KITITAS COUNTY

MEMORANDUM

TO: Dusty Pilkington, CDS
FROM: Justin Turnbull, County Surveyor
DATE: March 13, 2017
SUBJECT: County Survey Review of Crowley BLA 17-00001

**PART OF THE NORTHEAST QUARTER OF SECTION 16,  
TOWNSHIP 17 NORTH, RANGE 17 EAST, W.M.**

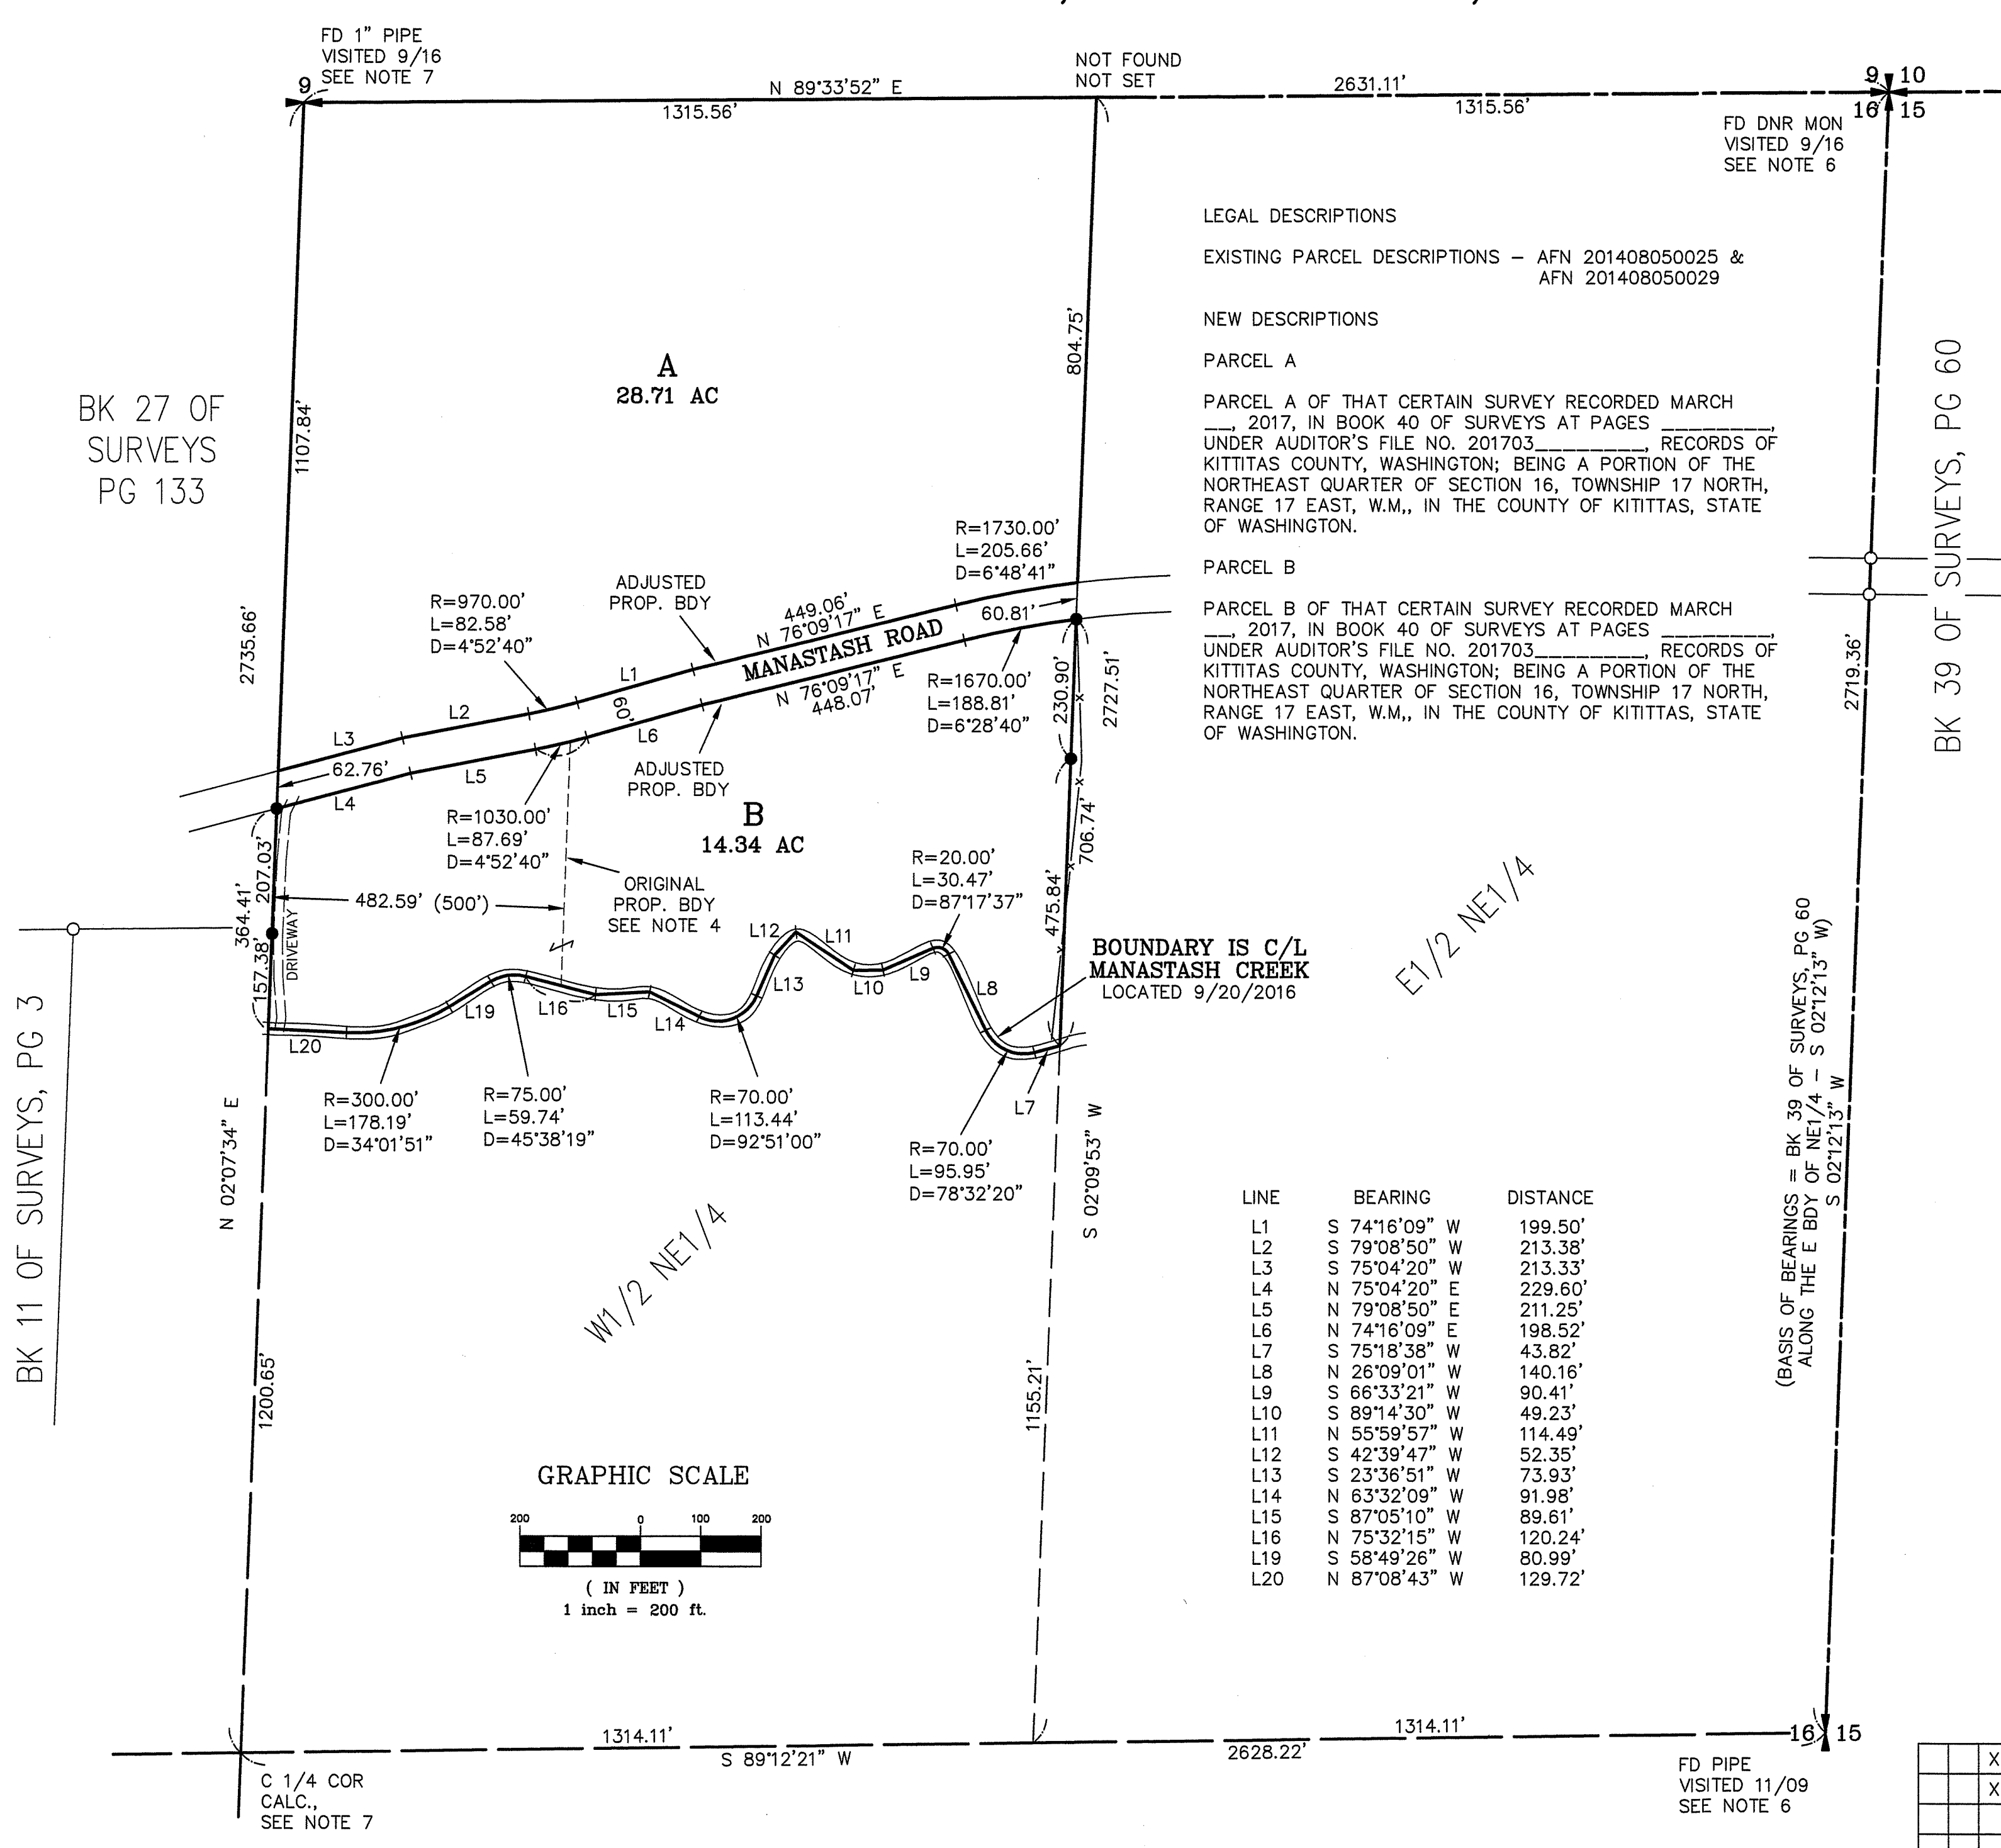
1. All roadways must show name, width, underlying ownership (private/county/state), easement or right of way, and surfacing material.
2. The source of the R/W for Manastash road should be identified (Field located centerline / Construction Documents)

3. The North Quarter Corner references B:27, P:133. This corner was not visited as part of the referenced survey. As such, a Land Corner Record should be created and filed, OR suitable references shown on the face of the survey to reset to GLO corner in the event of removal or destruction.

4. The Northeast Section corner references B:39, P:60. As the survey shows ties to (minimum) 2 other GLO corners, a LCR is not required, however the monument should be described in regards to type, kind, size, and surface markings.

5. The East Quarter Corner references B:39, P:60. As the survey does not shows ties to (minimum) 2 other GLO corners, a LCR or reference ties are required.

6. Found "Pin and Cap" should include notation describing what was physically found and any evidence (if any) of who set it.
